Engineers Comments Regarding Surface Water Drainage

Application Reference:	P/43/25/PL	Reviewer Reference:	ADC/SB
Planning Officer:	Hannah Kersley	Date of Review:	13/08/2025
Site Name:	Land to the west of Inglenook Hotel 255 Pagham Road Nyetimber PO21 3QB		
Application Description:	Demolition of existing storage buildings and the erection of 6 No dwellings and associated works. This application affects the setting of listed buildings, is a Departure from the Development Plan and is in CIL Zone 5 and is CIL Liable as new dwellings.		
Assessment Number:	1 of 1

- Flood Risk Assessment & Drainage Strategy, reference D2310/FRA1.1, dated 17/04/2025 and all plans contained within it. Referred to as the **FRA**.

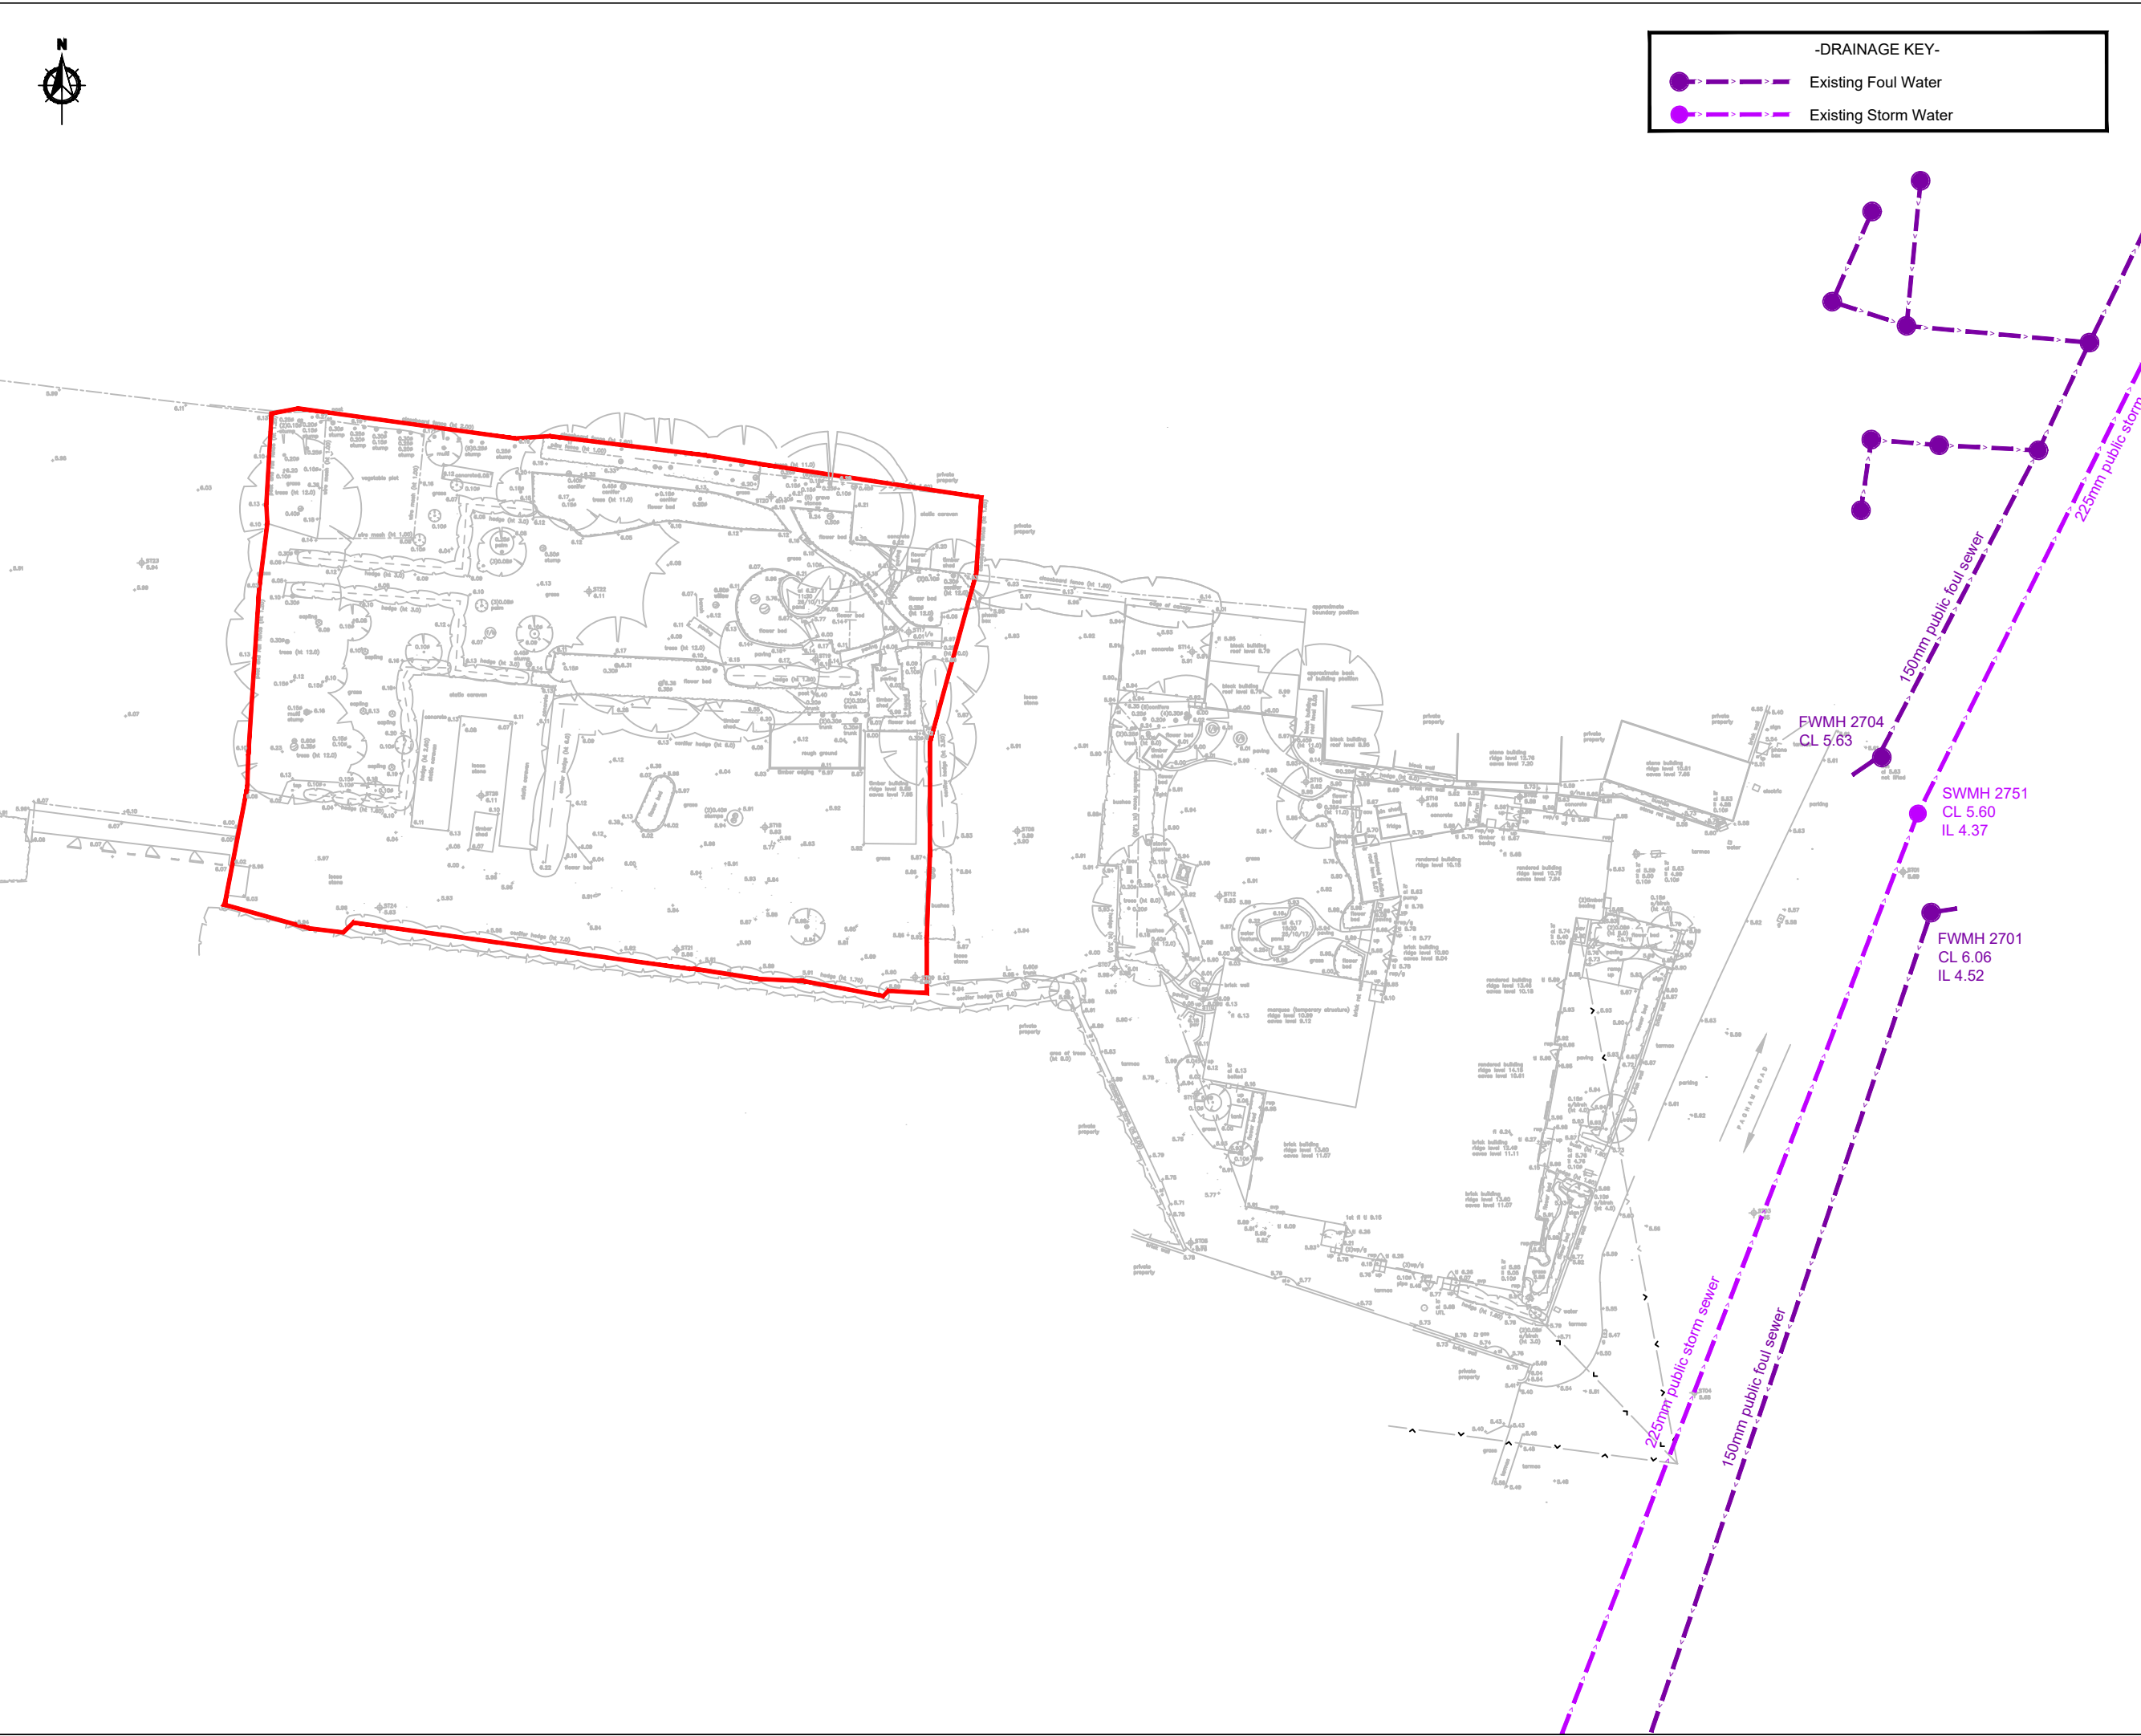
The access road is claimed to be ‘free draining’, this is inappropriate. Groundwater levels are high enough that they may penetrate the subbase of the access road and insufficient depth of unsaturated ground is provided between the base of the road and the peak groundwater level. This means that surface water will not be adequately treated. Furthermore, the infiltration potential of the site has not been demonstrated (due to high groundwater), therefore there is a risk that the access road will flood.
